SUBJECT: WDFW COMMENTS ON RU-25-00004 Thomas

Thank you for the opportunity to review and comment on Kittitas County reasonable use application RU-25-00004 Thomas, a proposal to construct a single-family residence, an outbuilding and associated infrastructure on Kittitas County parcel 186635. The Washington Department of Fish and Wildlife (WDFW) has reviewed the application materials on file and our comments are regarding the project's impact on Fish and Wildlife Habitat Conservation Areas (FWHCAs, CAO Chapter 17A.04), specifically riparian habitat.

Above: Proposed site plan with added buffer as mitigation for buffer impacts.

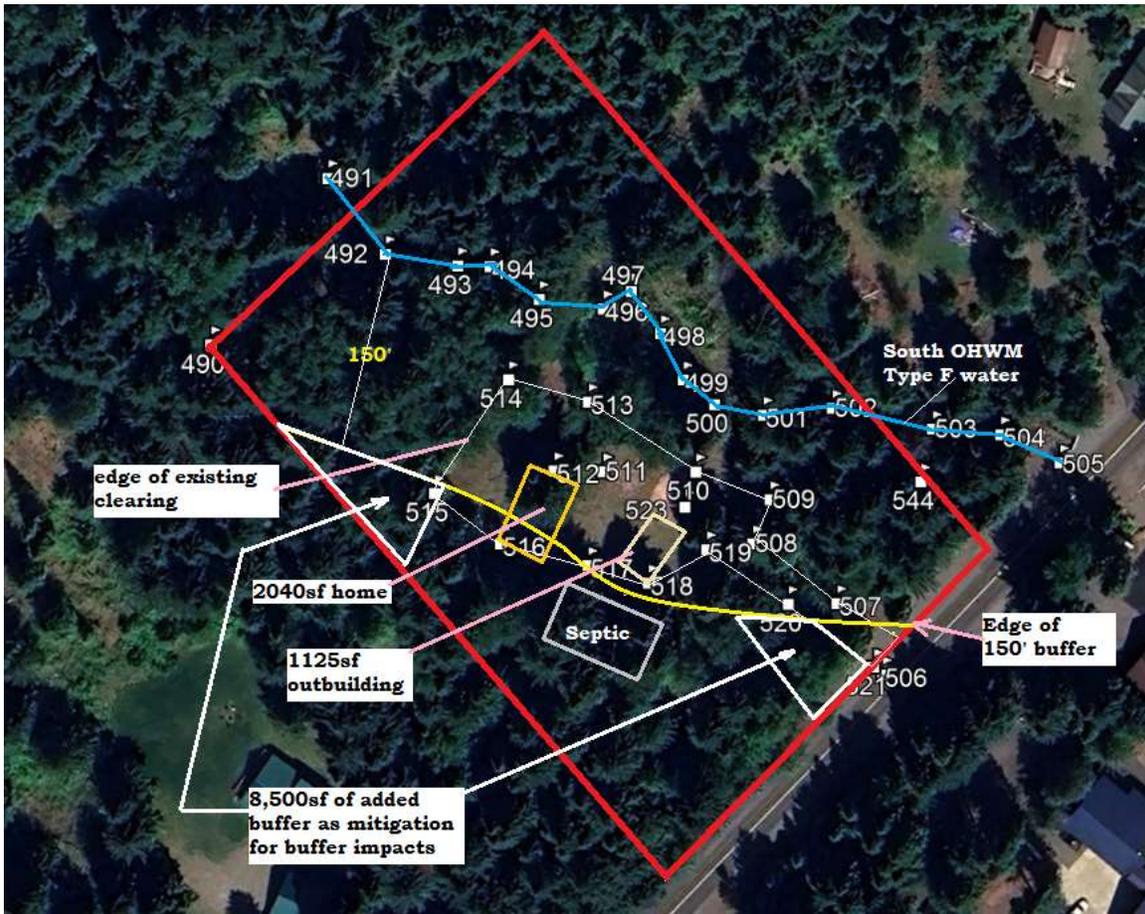
The critical areas report notes two different values for the permanent development impact (8,841sq ft and 8,481sq ft) and references the prior County CAO Standard RMZ widths for buffer protection. The critical areas report proposes to compensate for the permanent impact by adding 8,500sq ft to the riparian buffer on the southern portion of the property using buffer averaging. We don't see a plan/exhibit included with the application materials that specifically identifies where the 8,500sq ft proposed addition to the existing buffer is located. Further, WDFW believes preservation alone doesn't achieve no net loss. Are stream or riparian enhancements included in the proposal? Is the area fully within the RMZ identified by SPTH? How will the area be protected in perpetuity? We request additional information on the proposed mitigation to evaluate the adequacy and ensure no net loss of the riparian buffer function and value.

We recommend development of a mitigation plan, to be reviewed and approved by WDFW prior to construction, as a condition of the reasonable use determination. The mitigation plan should quantify the proposed mitigation measures and demonstrate equivalent or greater biological functions of FWHCAs consistent with Kittitas County's Critical Areas Ordinance (CAO 17A.04.070). If developing a planting plan, it should include monitoring to ensure survivability of the planted plants. We recommend at least three years of monitoring with an 80% survivability. If metrics fall below 80%, we recommend that similar plants be planted to replace those that did not survive.
